A38 Derby Junctions
TR010022
8.3 Responses to Relevant
Representations

Responses to Relevant Representations

Regulation Number	Rule 8 (1)(c)(i)
Planning Inspectorate Scheme Reference	TR010022
Application Document Reference	TR010022/APP/8.3
Author	A38 Derby Junctions Project Team, Highways England

Version	Date	Status of Version
Version 1	05 November 2019	Deadline 1 Submission

**Little Eaton Junction Existing & Proposed Rights of Way Plan**

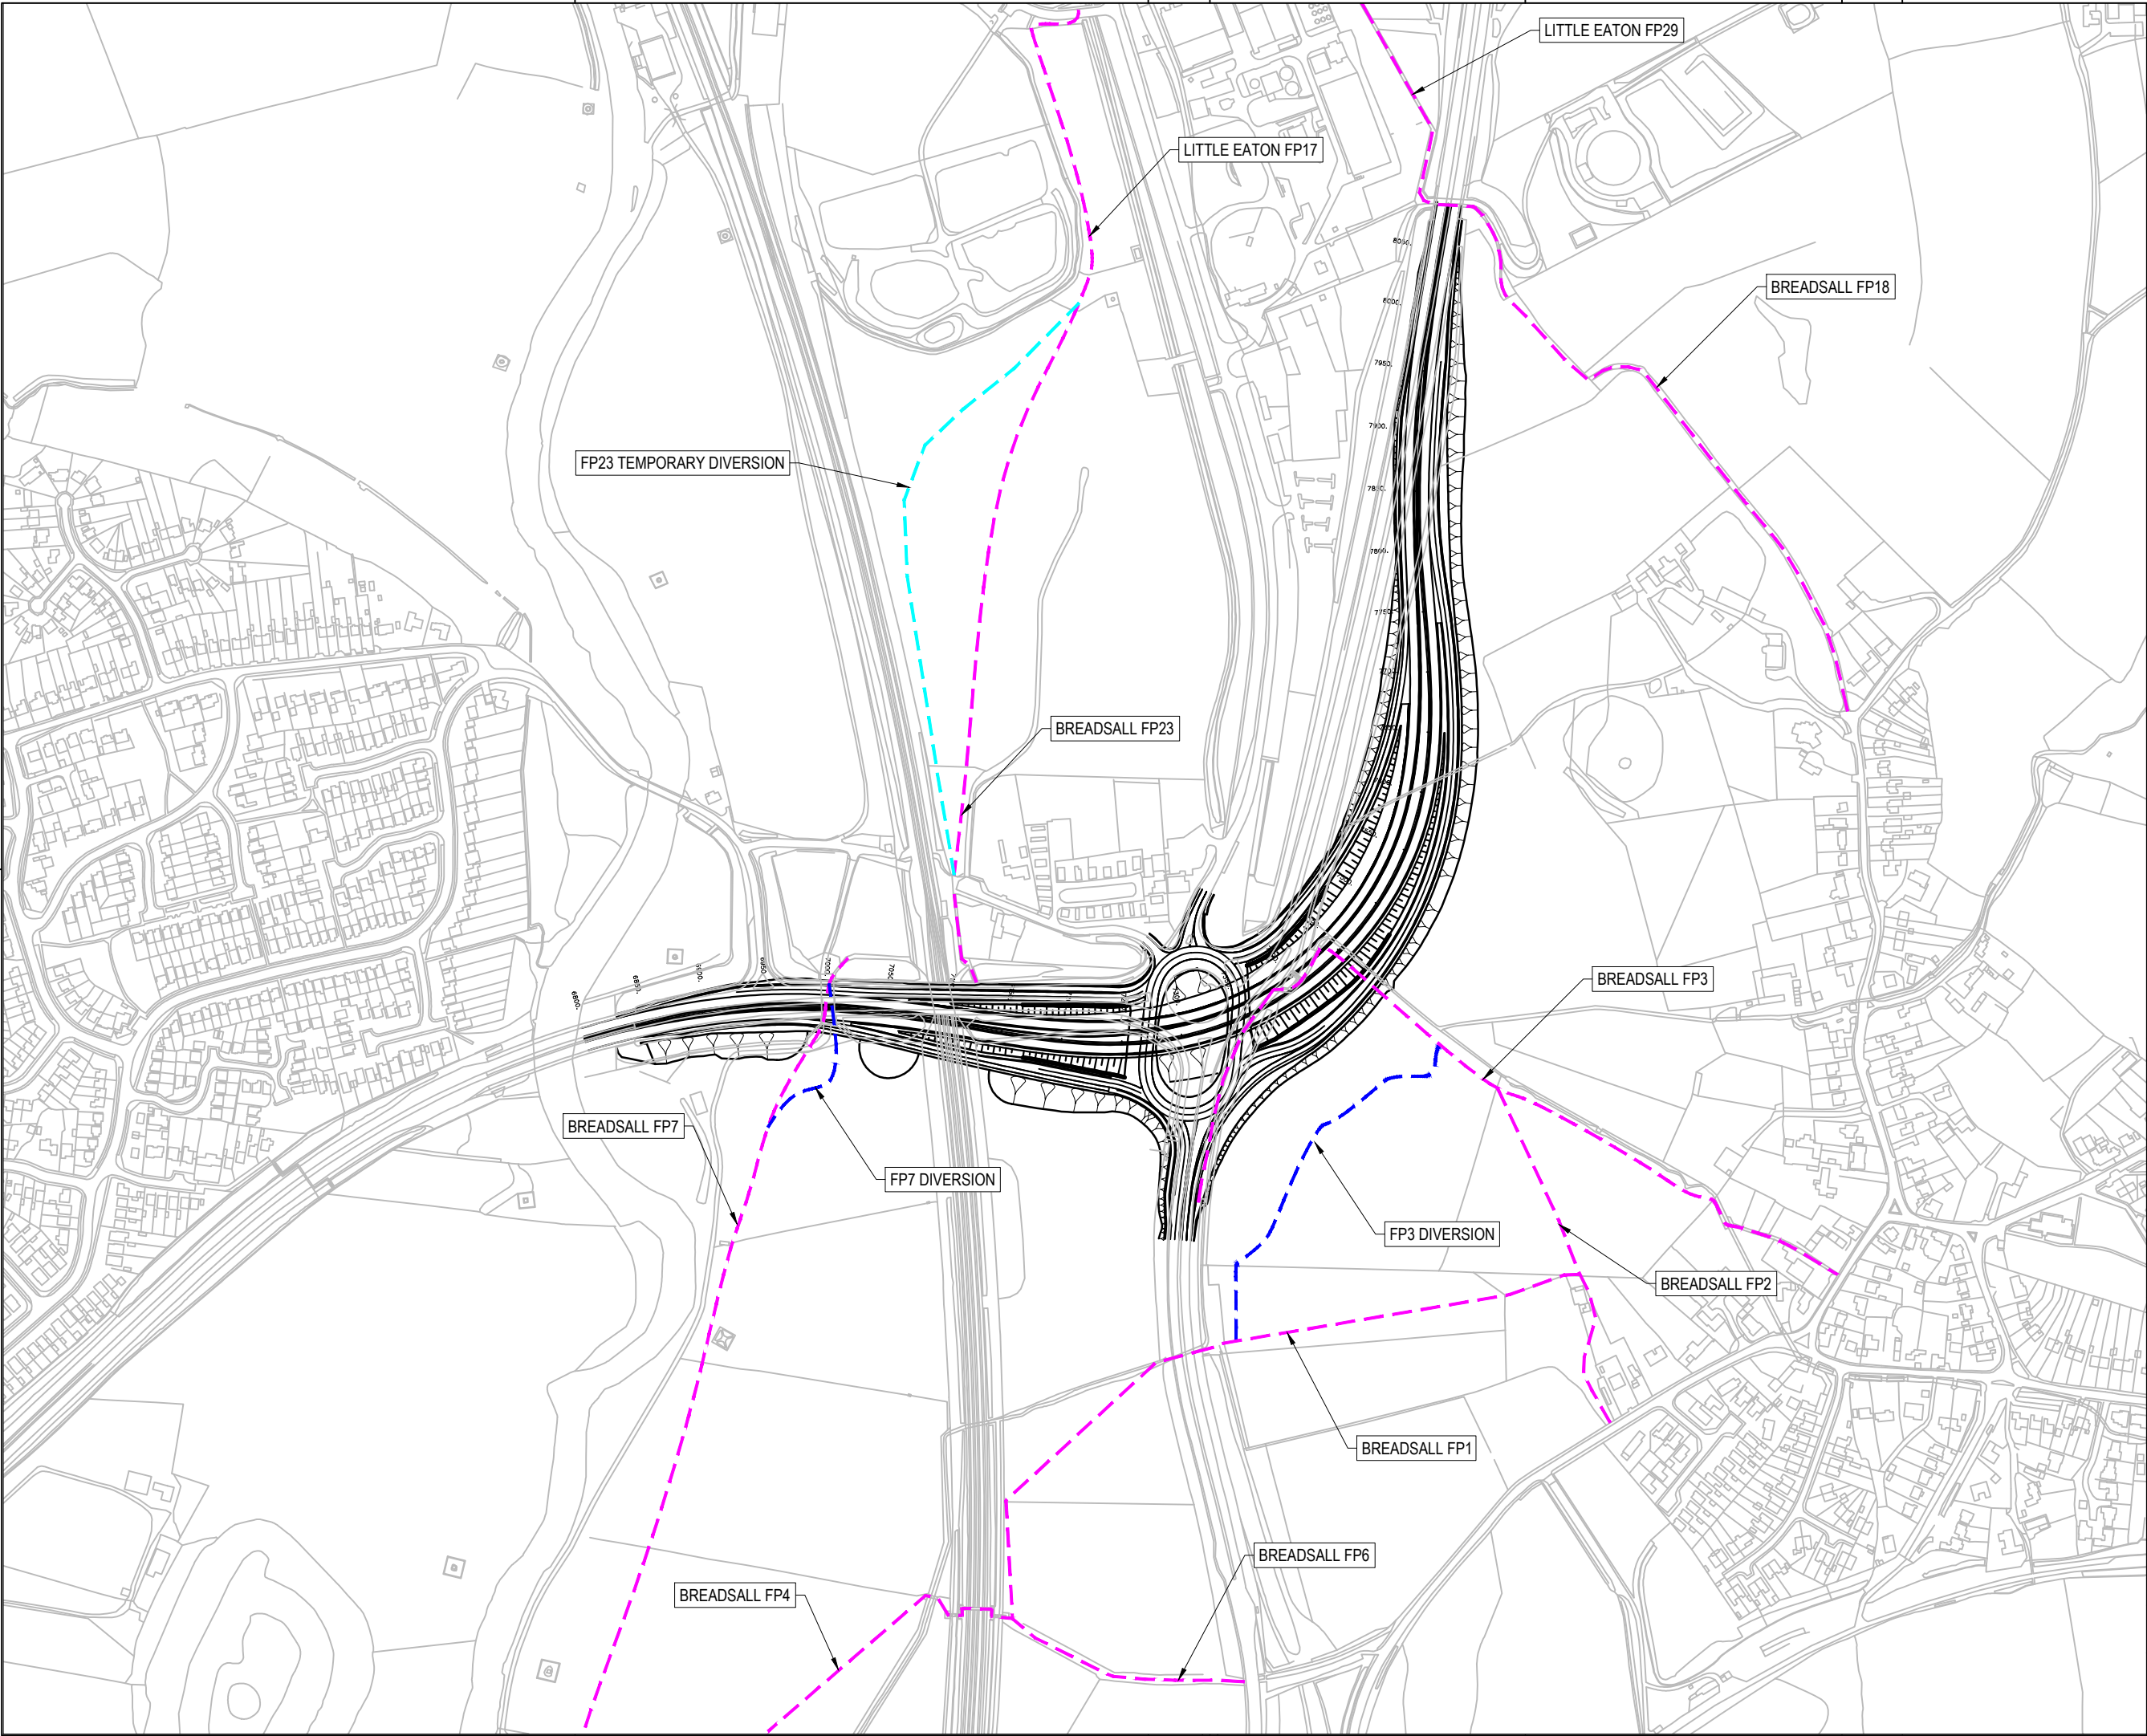
RR-001e	d) There is currently a footpath which leads from Rectory Lane Breadsall directly to the A38 and the B6179 just north of the A38/A61 roundabout. The proposed diversion of this footpath appears to sever this route and involve an extremely circuitous detour via a new toucan crossing far to the south on the A61. This detour is unacceptable and a footpath route approximately equivalent to the present one must be provided.	The proposed diversion to the footpath leading from Rectory Lane toward the A38 has been discussed with Derbyshire County Council's Rights of Way team. Given the safety aspects associated with facilitating a crossing point for the footpath where it emerges from the fields to the south east corner of the junction, the Council's Rights of Way team felt that making this a circular route to link with another footpath leading from Croft Lane would be preferable. This particular route has little observed use and safer facilities are being provided at the existing crossing of the A61 from Croft Lane.
